Our ref: B-0939-220-01_Rev2

16 December 2022

Re: Bowdens Silver - Geochemistry Peer Review

Figure 7 –WRE cells layout.

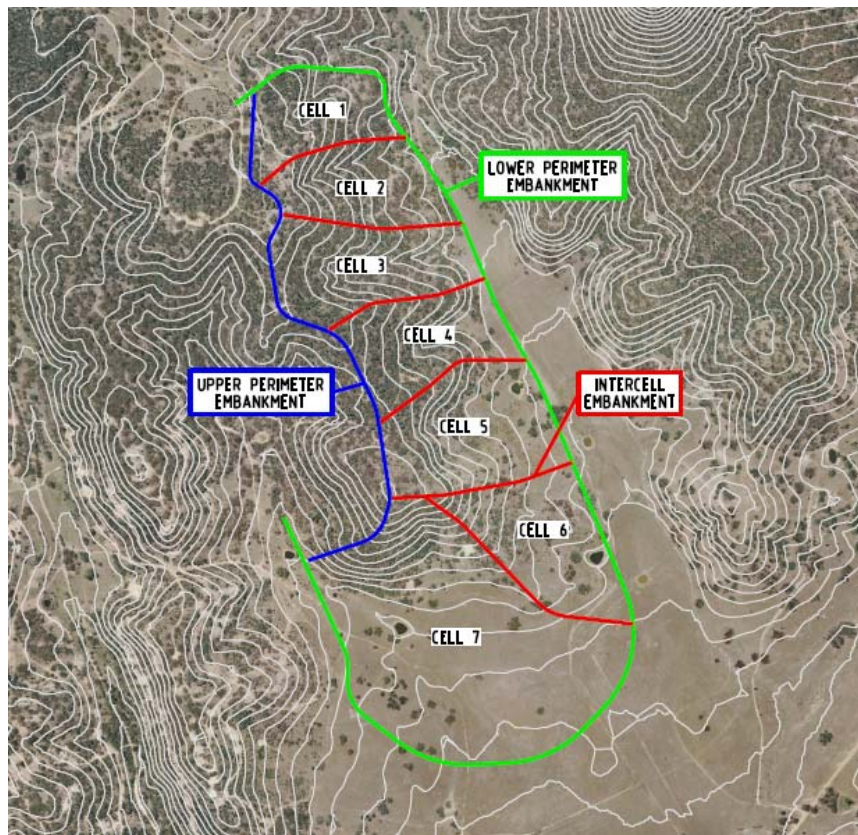
The focus of this review is on geochemical aspects of the WRE design and AMD risk management. As noted, Okane's opinion is that the design is robust in this respect for this stage of the product. As the Project matures, evaluation of geotechnical stability in the context of the WRE's design to manage AMD risk should be refined. For example, a stability analysis on the design as proposed for evaluation of all potential slip failure and shear failure planes and consideration of pore-water pressure increase in response to loading given that the liner represents a seepage barrier for consolidation seepage waters.

Recommendation #10: Okane recommends Bowdens Silver complete, if it has not already been done so, a landform (global) stability analysis for operational and closure conditions, as well as for near surface (vener) stability; these must be conducted for static and dynamic conditions, and for the WRE design as proposed.
